CITY OF ALBUQUERQUE

Re: Storage Building, 420 Pennsylvania SE
Request for Certificate of Occupancy
Transportation Development Final Inspection
Architect's Stamp dated 12-23-14 (K19D149)
Certification dated 10-24-17

SITE PLAN

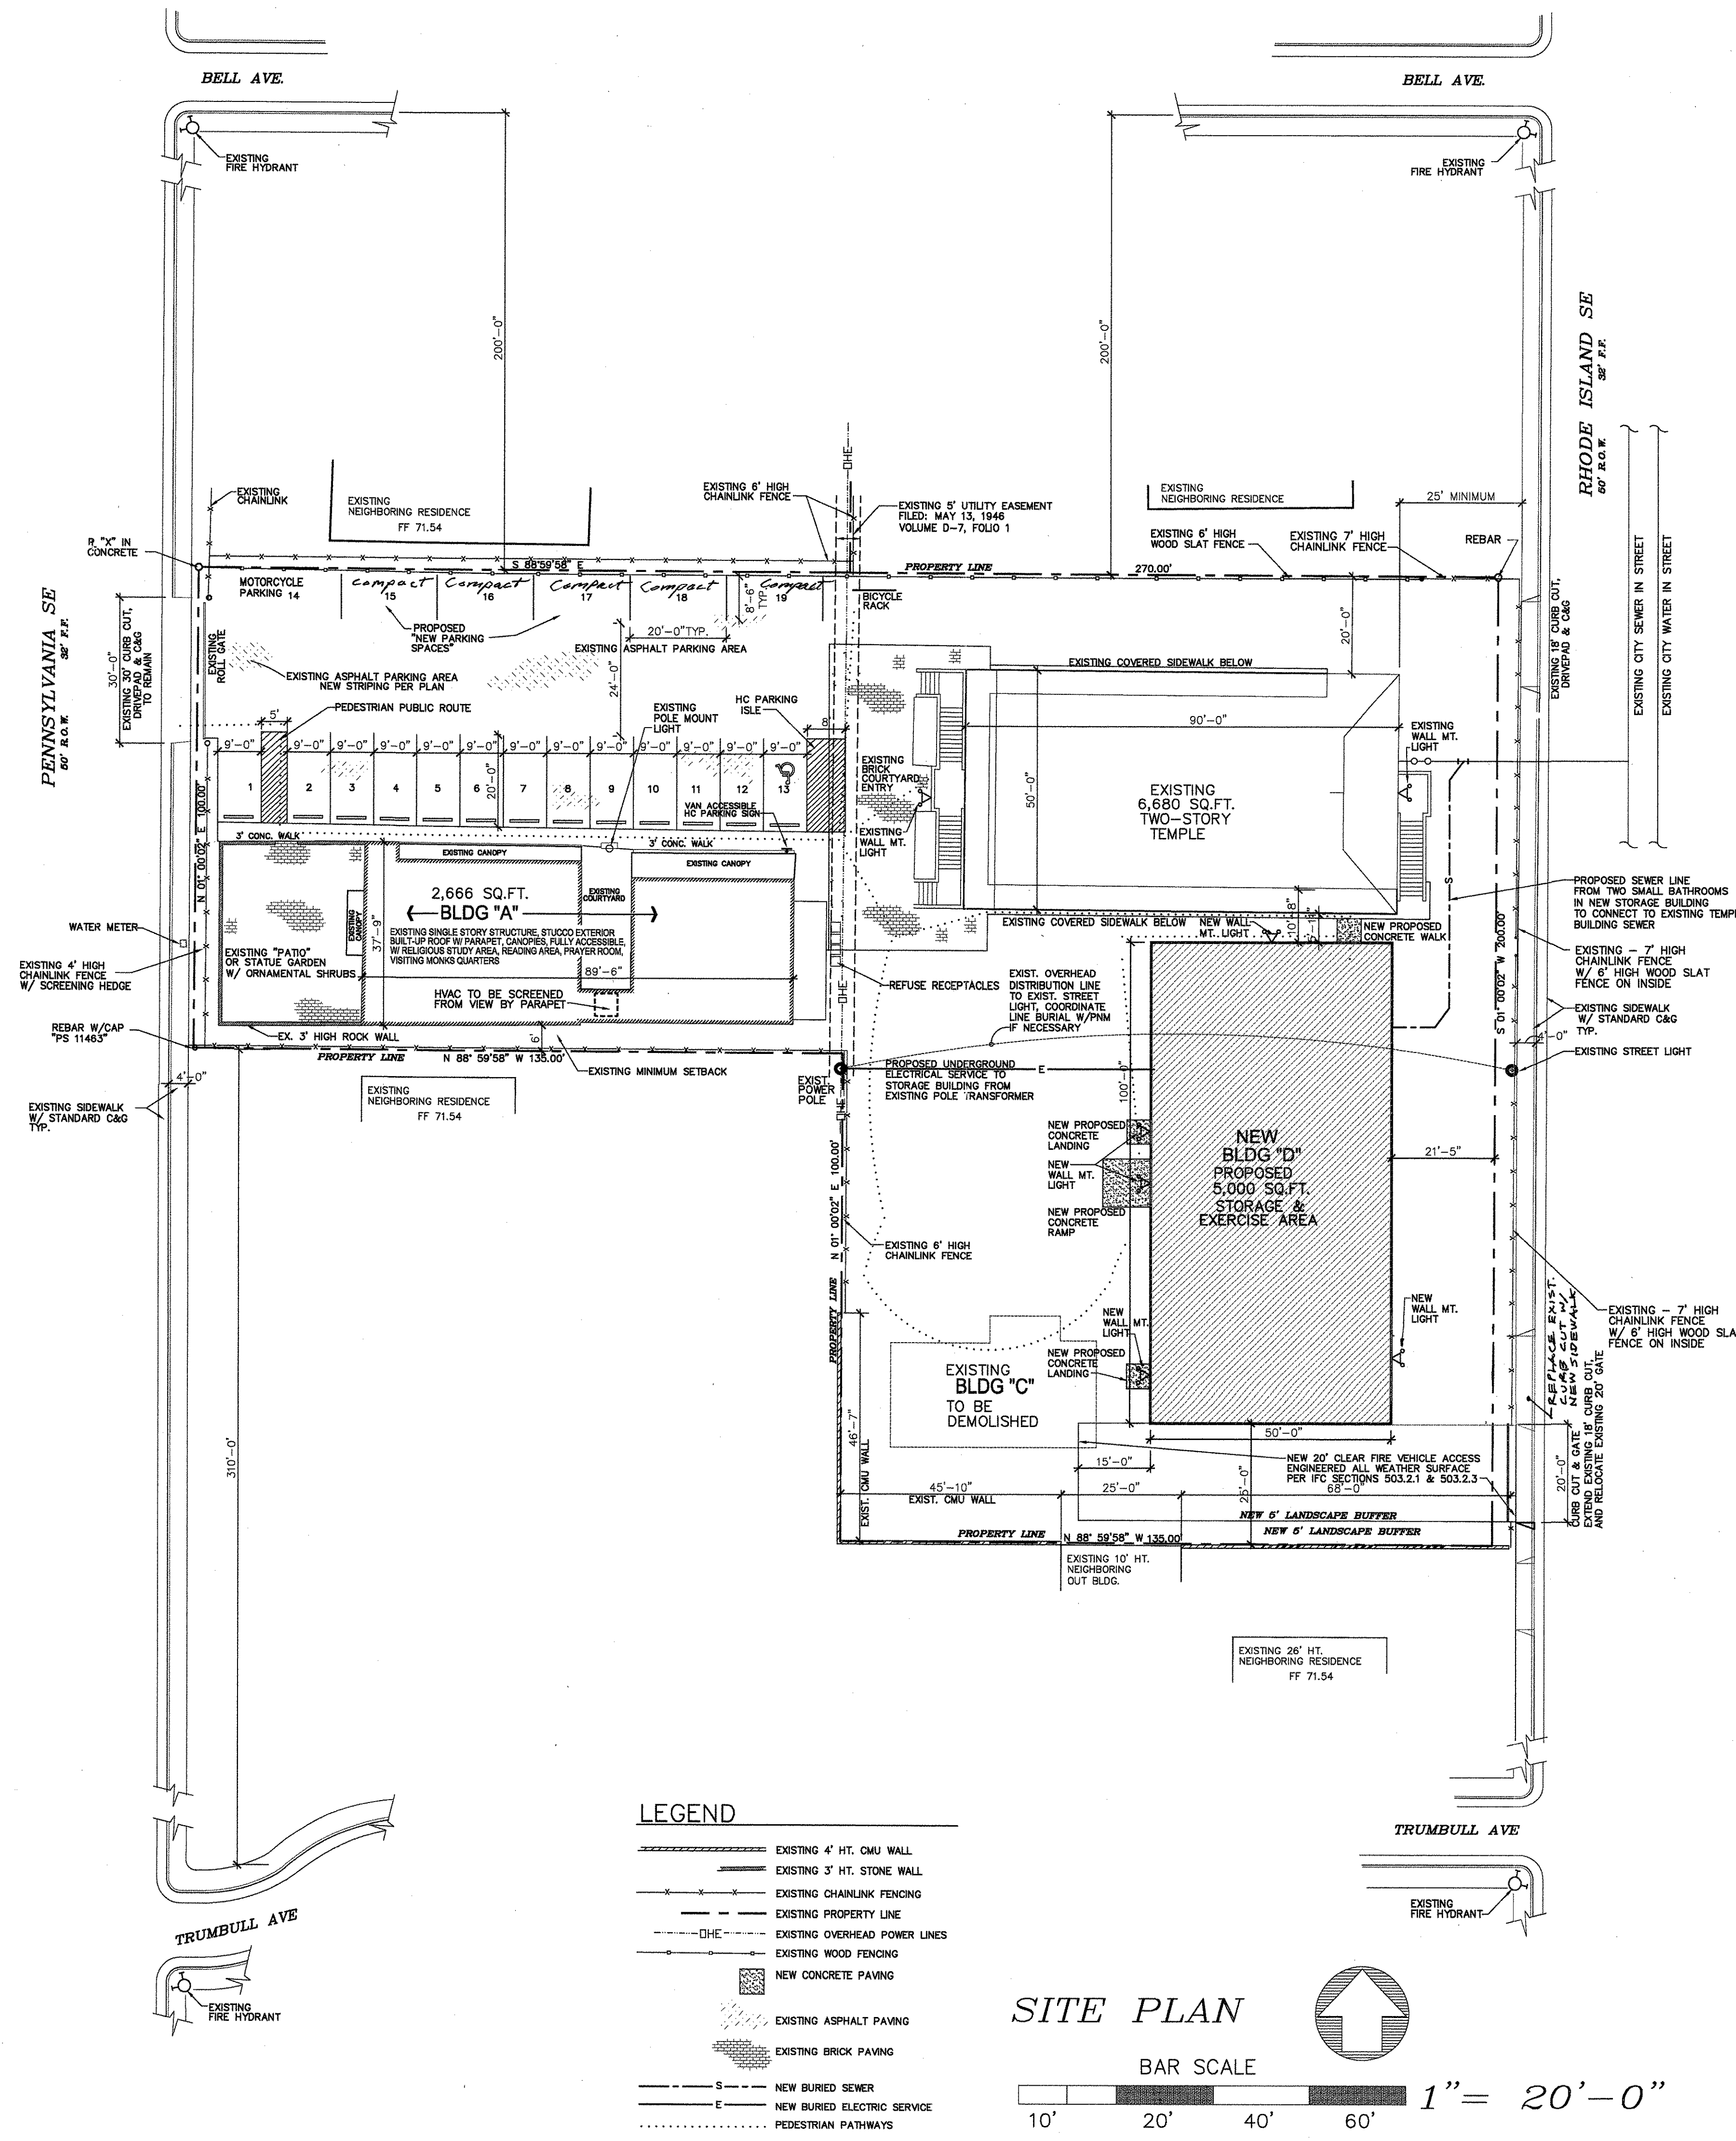
Based upon the information provided in your submittal received 10-25-17, Transportation Development cannot approve the release of Certificate of Occupancy for the above referenced project. Prior to the issuance of a permanent Certificate of Occupancy, the following items must be addressed:

- The proposed parking area improvements have not been constructed per plan.
- The ADA accessible parking sign must have the required language per 66-7-352.4C NMSA 1978 "Violators Are Subject to a Fine and/or Towing." Please call out detail and location of HC signs.
- The ADA access aisles shall have the words "NO PARKING" in capital letters, each of which shall be at least one foot high and at least two inches wide, placed at the rear of the parking space so as to be close to where an adjacent vehicle's rear tire would be placed. (66-1-4.1.B NMSA 1978)
- Label the compact parking spaces by placing the words "COMPACT" on the pavement of each space.
